Preliminary Report on Metrolink Route and its Potential Effect on AerCap House

Waterman Moylan Consulting Engineers Limited

Client Name: Hines
Document Reference: 22-117r.101
Project Number: 22-117

Scale @ A3  
1:10,000  
DO NOT SCALE

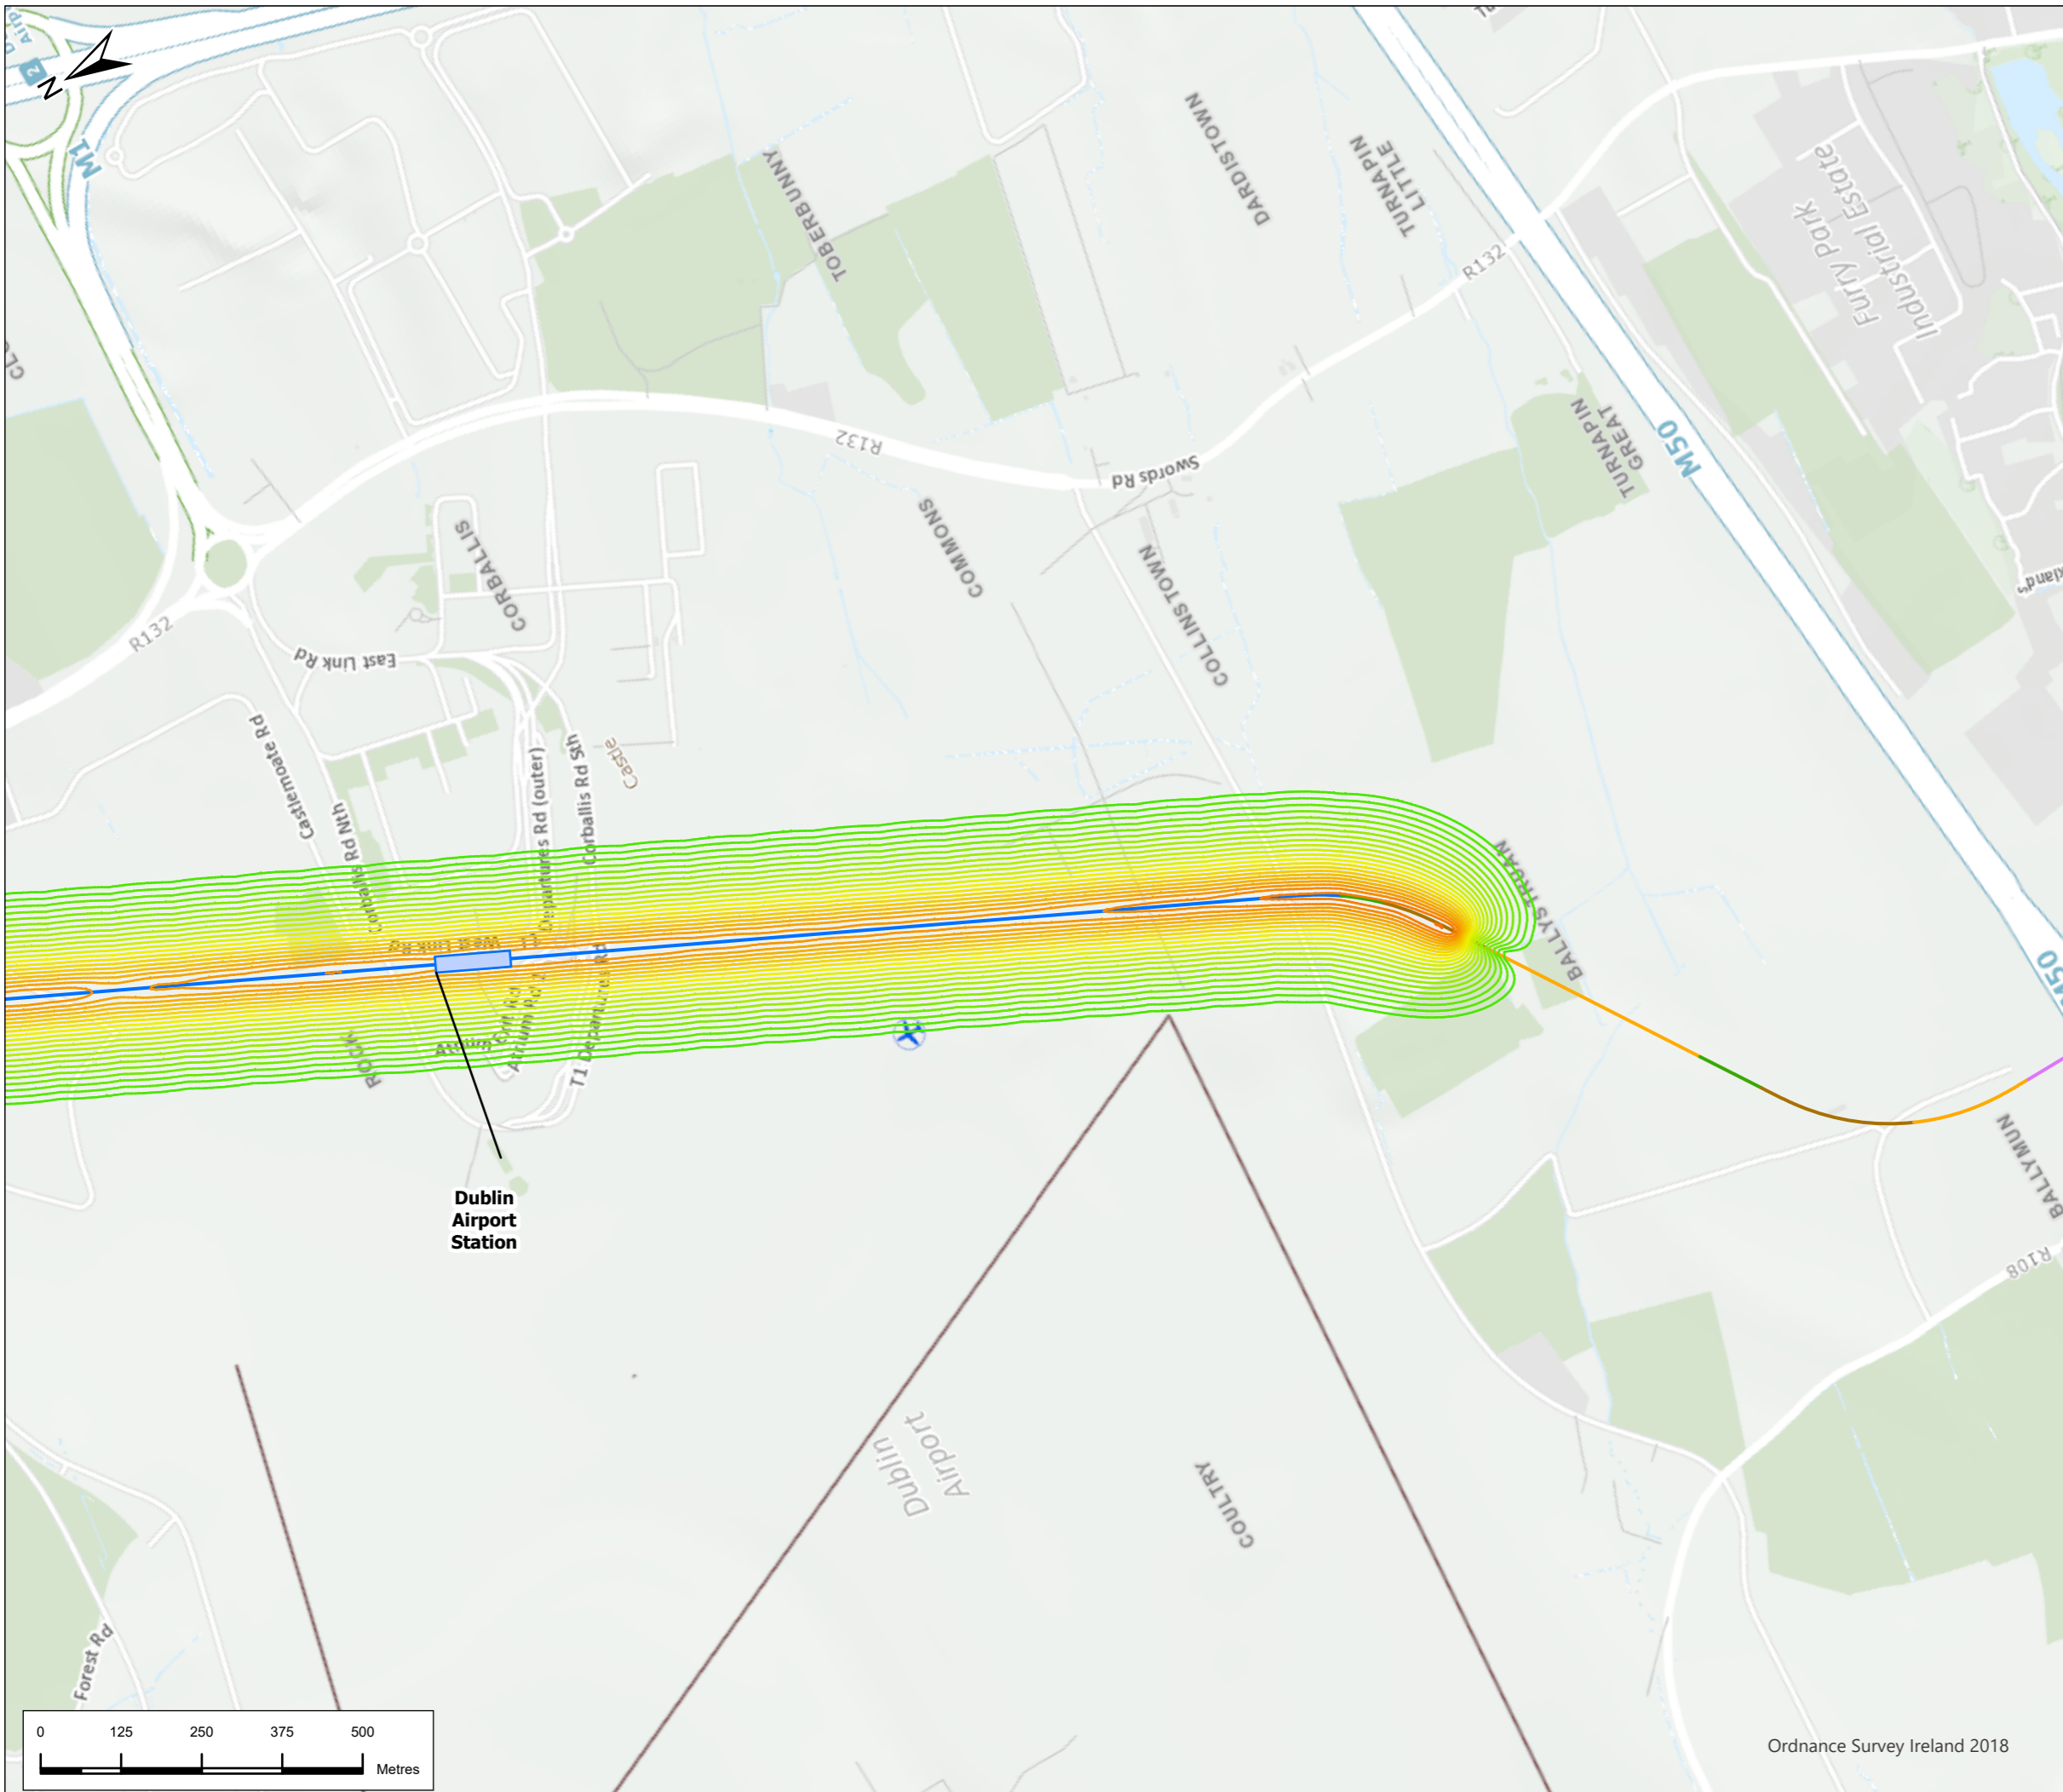
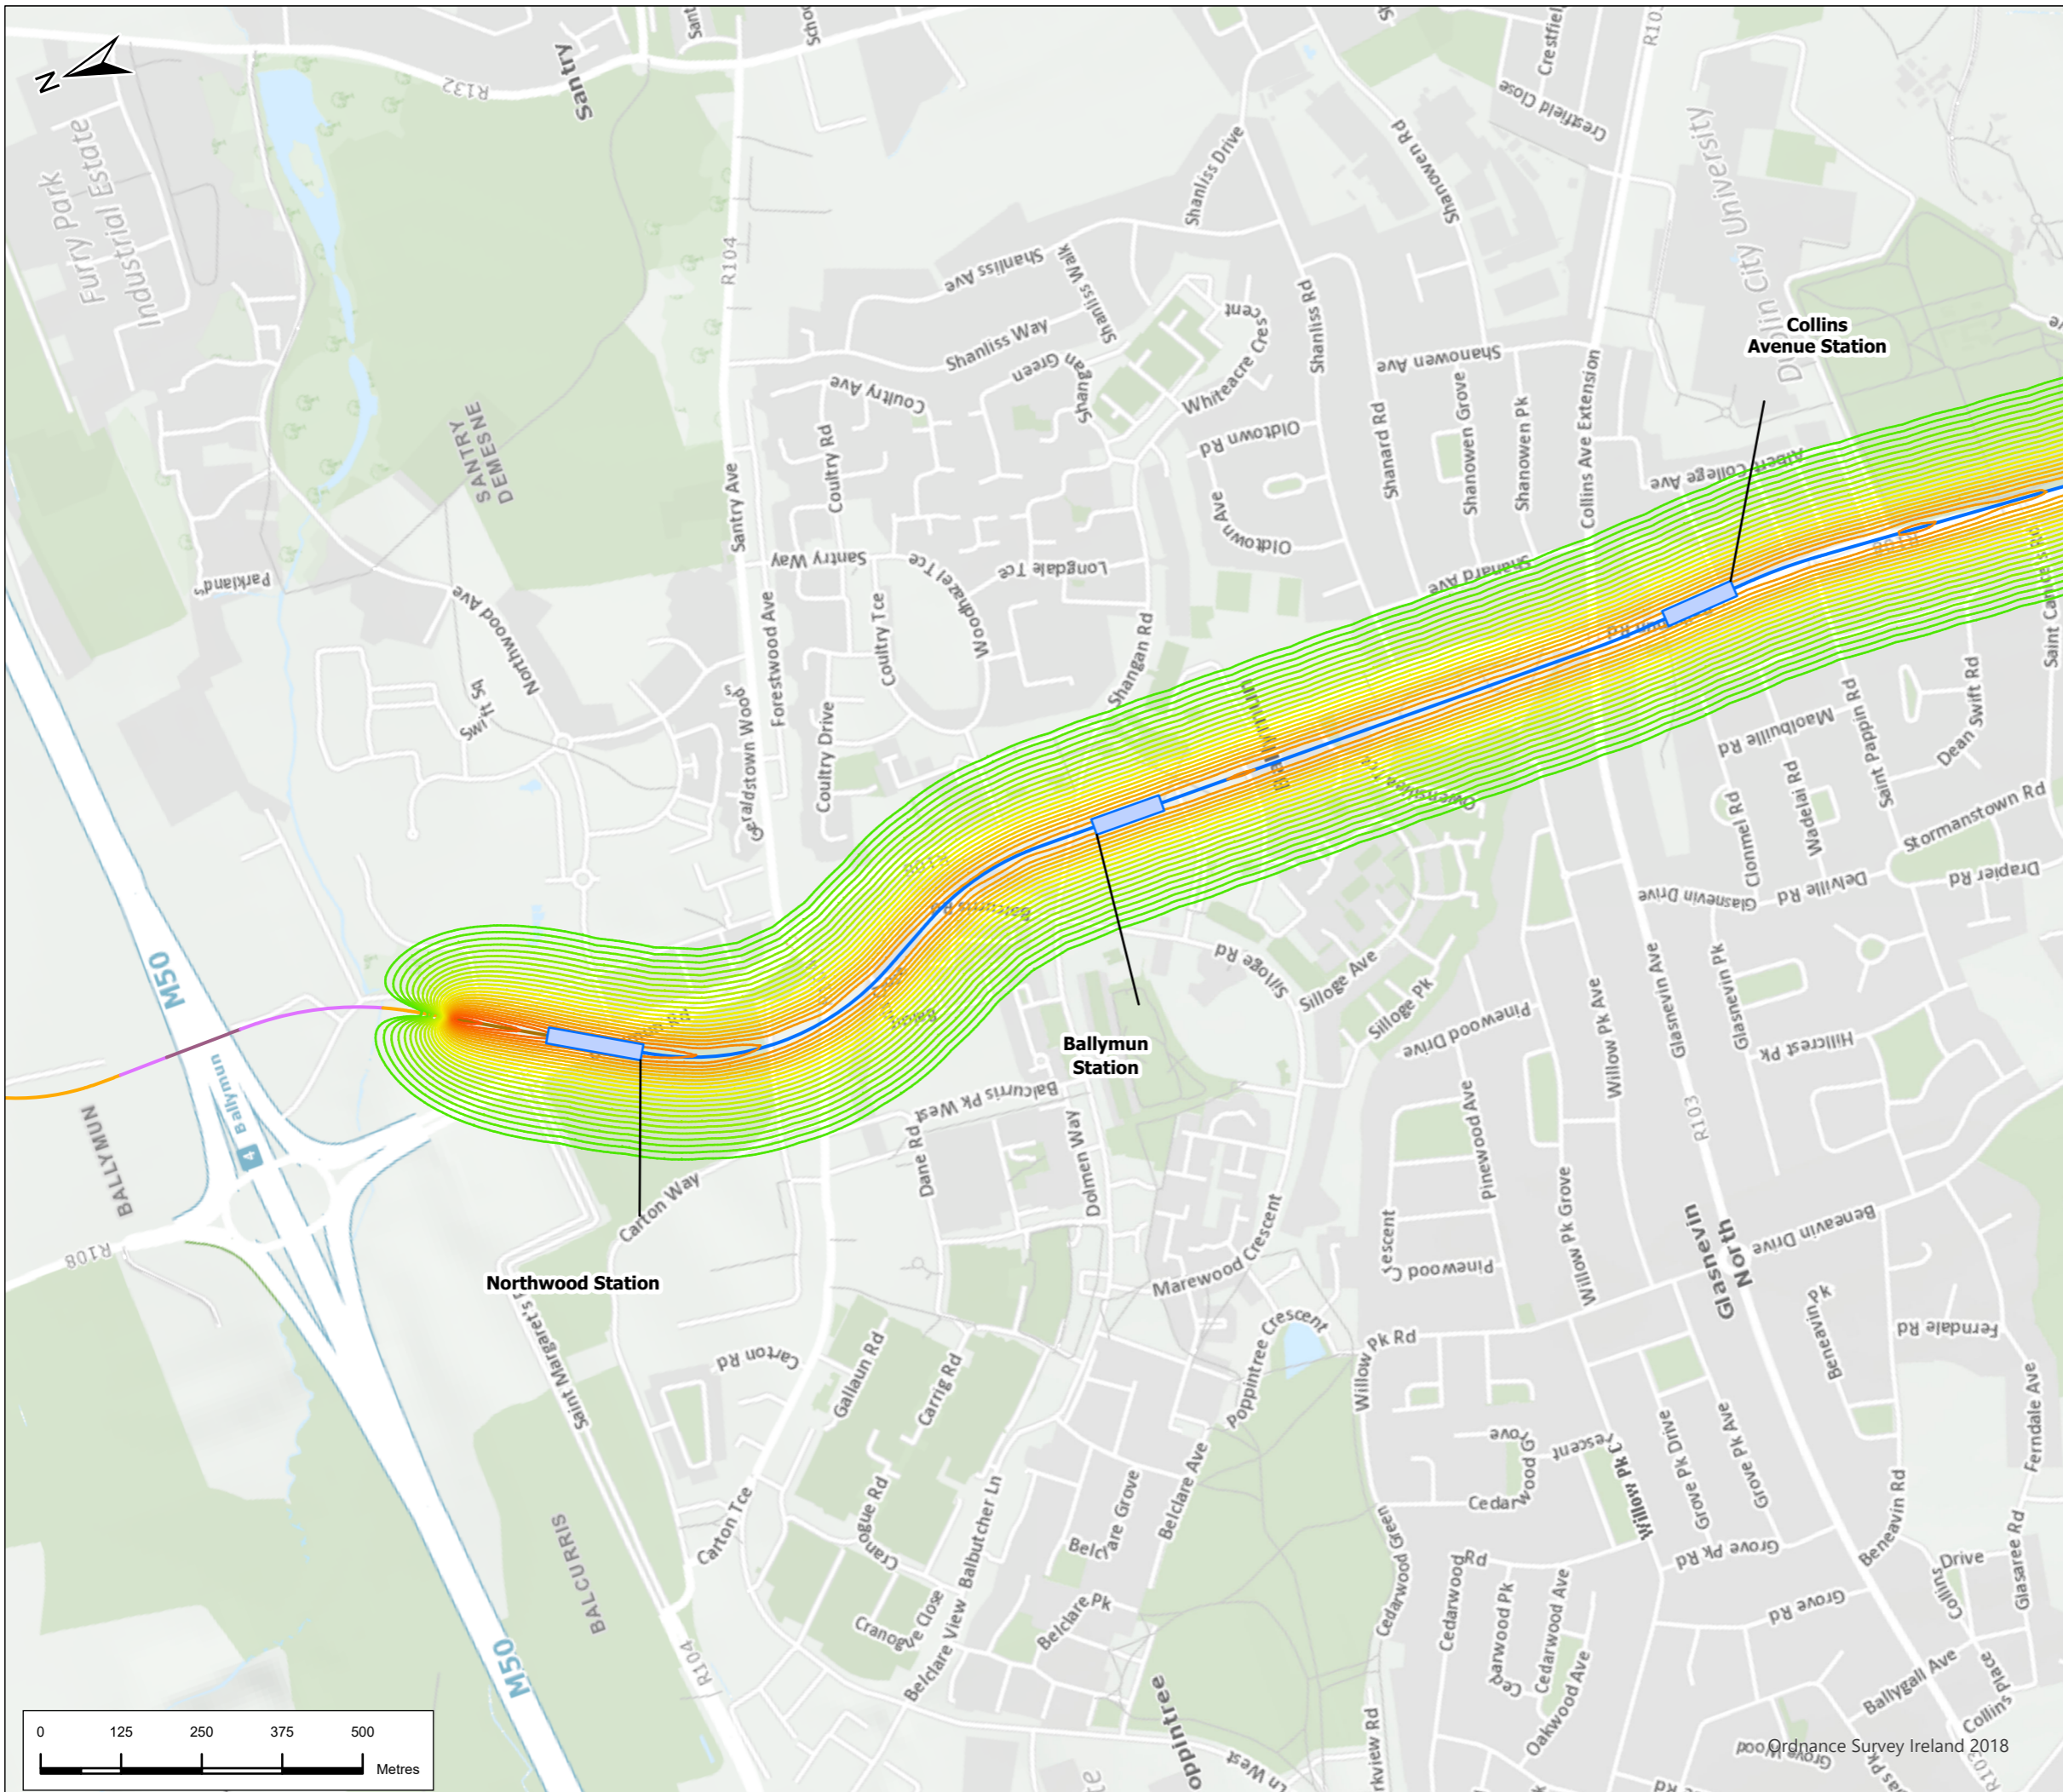
Observation (Waterman Moylan) 2: The construction information provided by MetroLink has been reviewed. We refer to the following points: a) Metrolink has assessed the "Groundborne Noise from Tunnel Boring Machine" and presents its findings on drawing no. ML1-JAI-EIAROUT-XX-DR-Y-14009 (a copy is attached to this submission). This drawing indicates MetroLink will generate an additional 50db directly under the location of our Client's building which is unacceptable.

Waterman Moylan Response 2: The response suggests that we need to accept the nuisance caused by the proposed works, and there is nothing that TII are willing to undertake to prevent this nuisance.

TII Response 2: *"Appendix 14.5 Groundborne Noise and Vibration Blasting Modelling Results presents predicted groundborne noise and vibration levels during the construction and operation phase of the project. The prediction of groundborne noise during TBM passage for the AerCap House (65 St. Stephen's Green) is 49 dB LASmax, which is above the 45 dB LASmax threshold, resulting a significant impact on the buildings operation for the limited duration of TBM passage. Unfortunately, there are no effective methods available to reduce groundborne noise or vibration from TBMs at source, but noting that the duration of this impact will be in the order of up to two weeks as the TBM passes. It is important to note that the noise level as the TBM passes will be noticeable and perhaps disturbing for some, but will not cause any damage to the property. TII will liaise with Hines Real Estate Ireland Limited to ensure the timing of these impacts are known. The principal mitigation measures aimed at minimising impacts are as follows:*

- *Advance public consultation and stakeholder engagement can greatly reduce the significance of groundborne noise effects, as building occupants would be prepared for the passage of the TBM and resultant elevated noise and vibration levels.*

- *TII will accept and consider applications for additional measures on a case-by case basis, in accordance with its Noise and Vibration Mitigation Policy (see EIAR Appendix A14.6, Airborne Noise & Groundborne Noise Mitigation Policy)."*
